Department for Transport

28 OCTOBER 2020

PLANNING ACT 2008: APPLICATION FOR A NON-MATERIAL CHANGE TO THE ABLE MARINE ENERGY PARK DEVELOPMENT CONSENT ORDER 2014

Drawing file: published-documents / TR030001-003455-Able NMC - Tab 3(1) - Substitute Plan - AME - 02006 C Indicative Masterplan.pdf

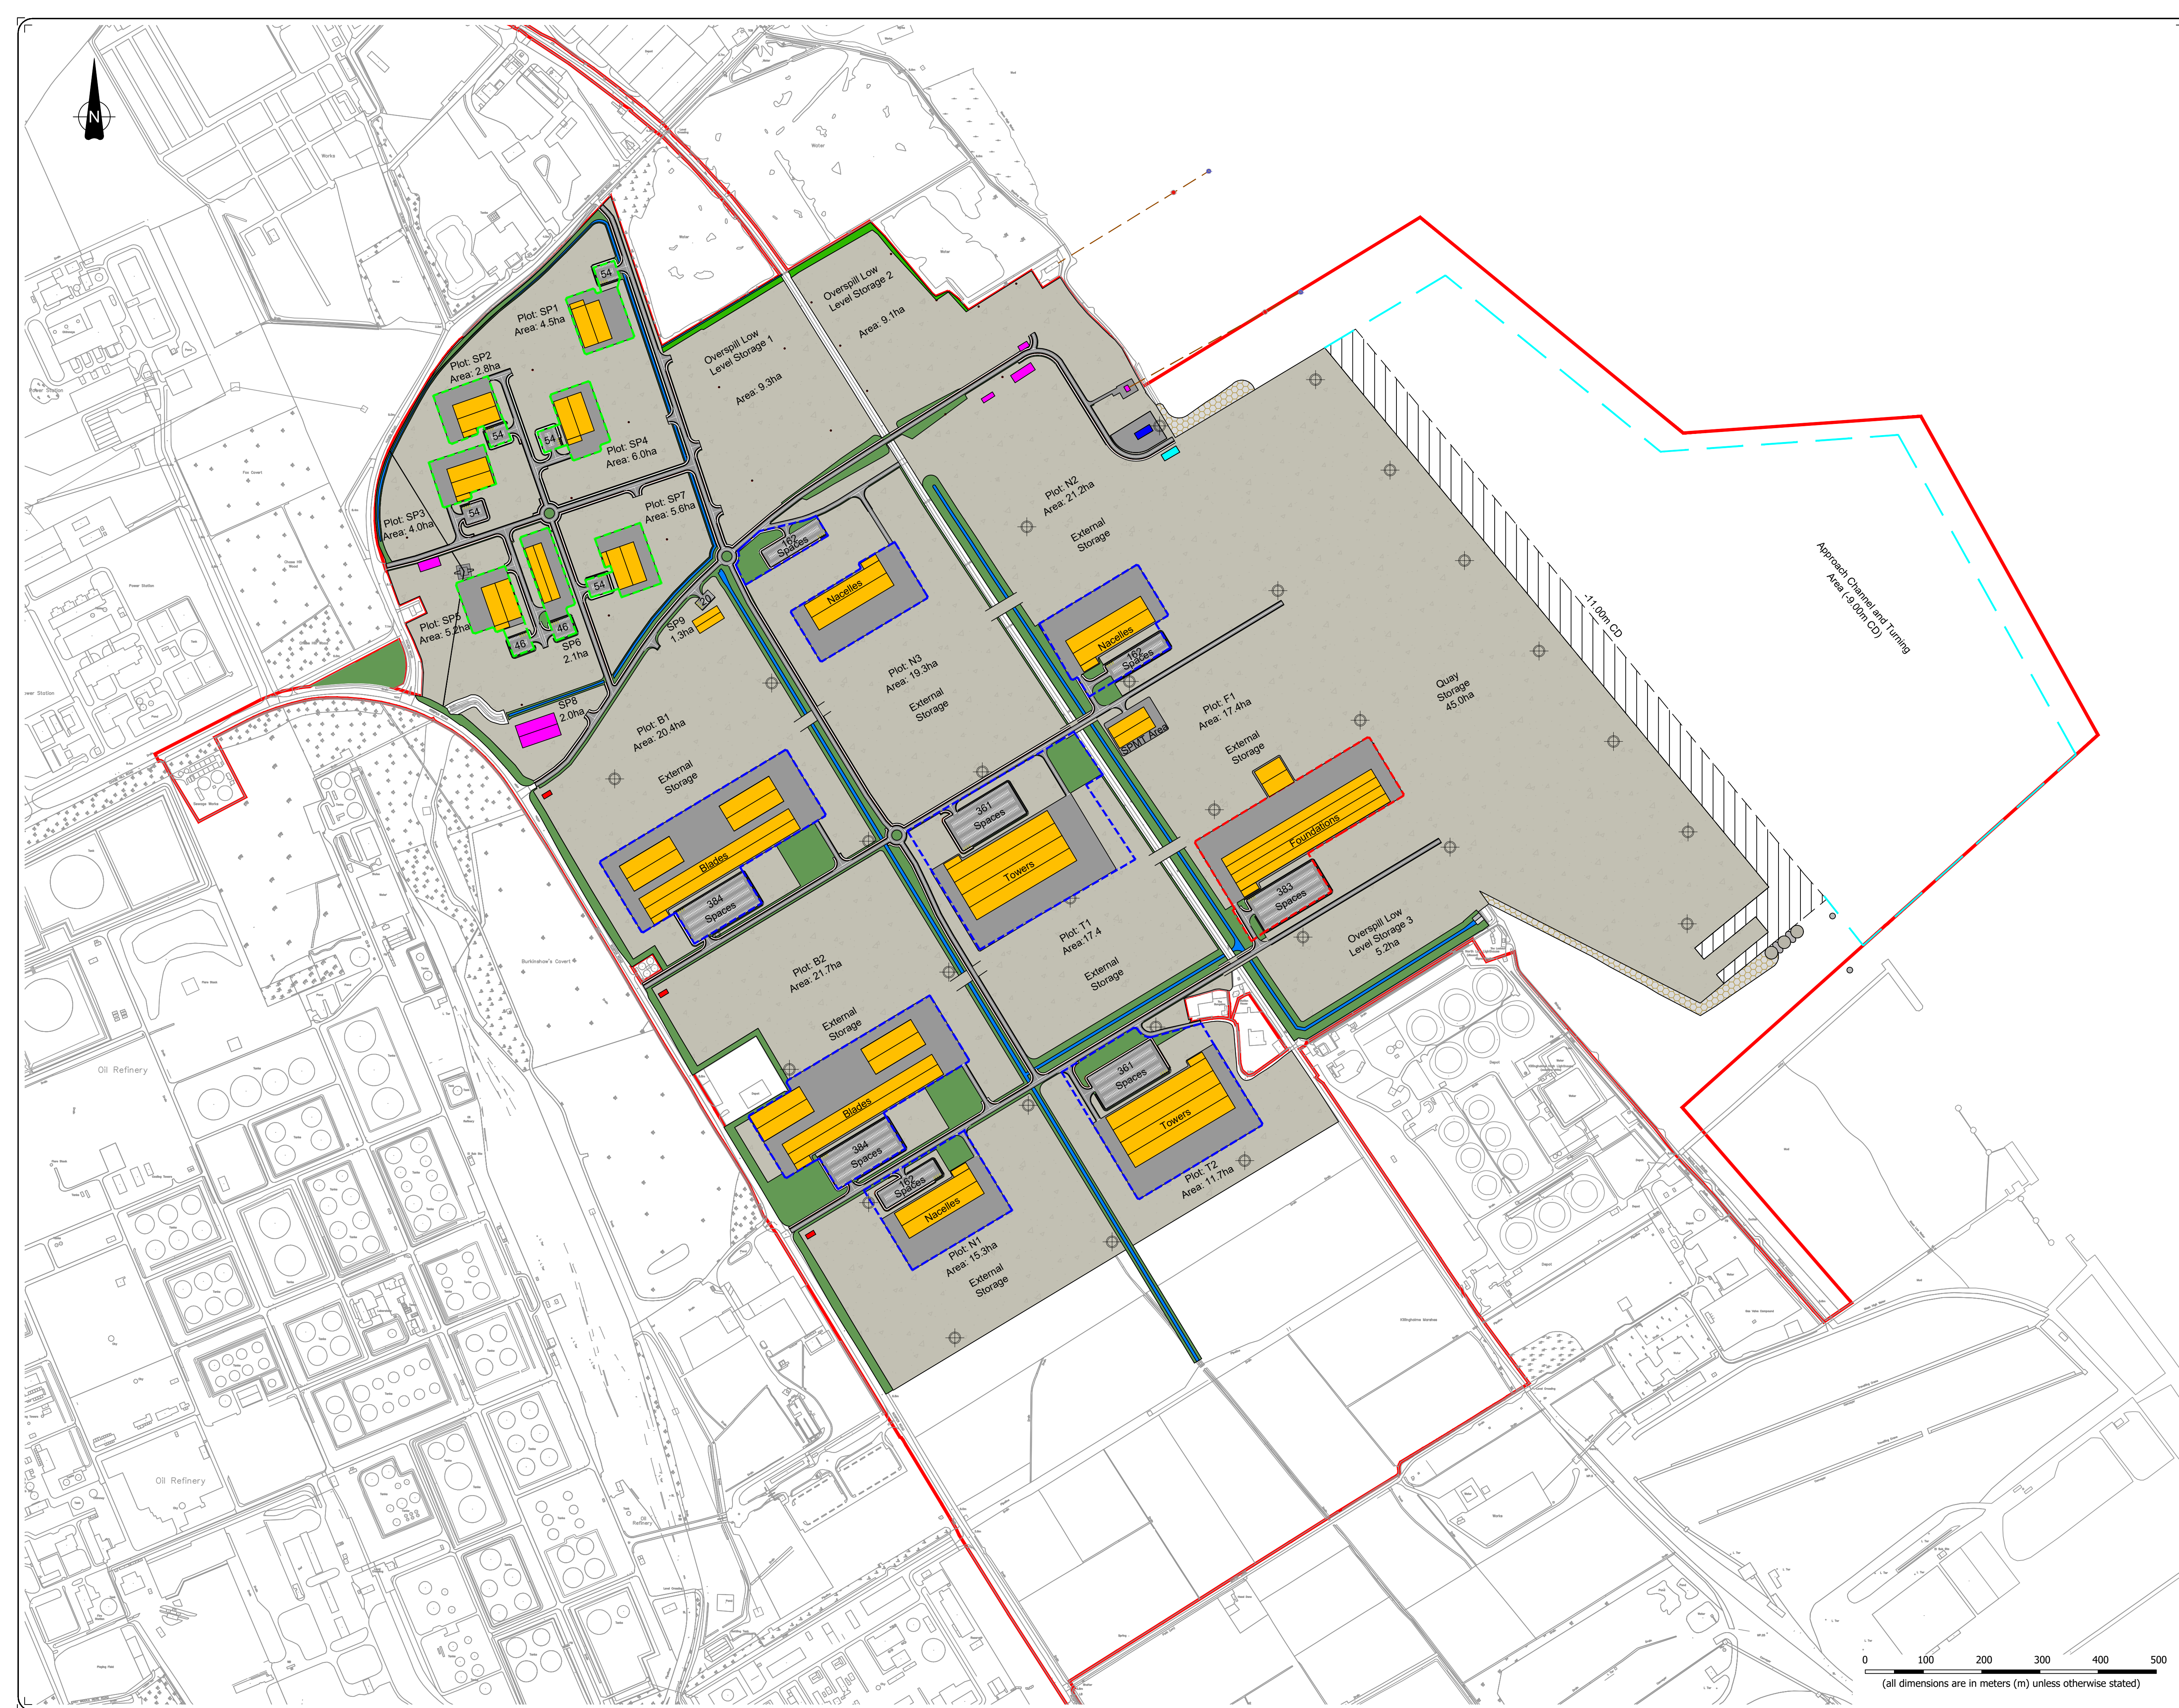
30. The Secretary of State notes that the ‘non-material change indicative masterplan’ (AME-02006c) submitted as part of this application removes the authorised buffer zone and original Mitigation Area A shaded area that was included in the authorised masterplan from 2012 (AME-02006A). The order limits are not amended by AME-02006c. The Secretary of State notes the Applicant’s conclusion in the supporting environmental information is that the original assessment findings remained valid.
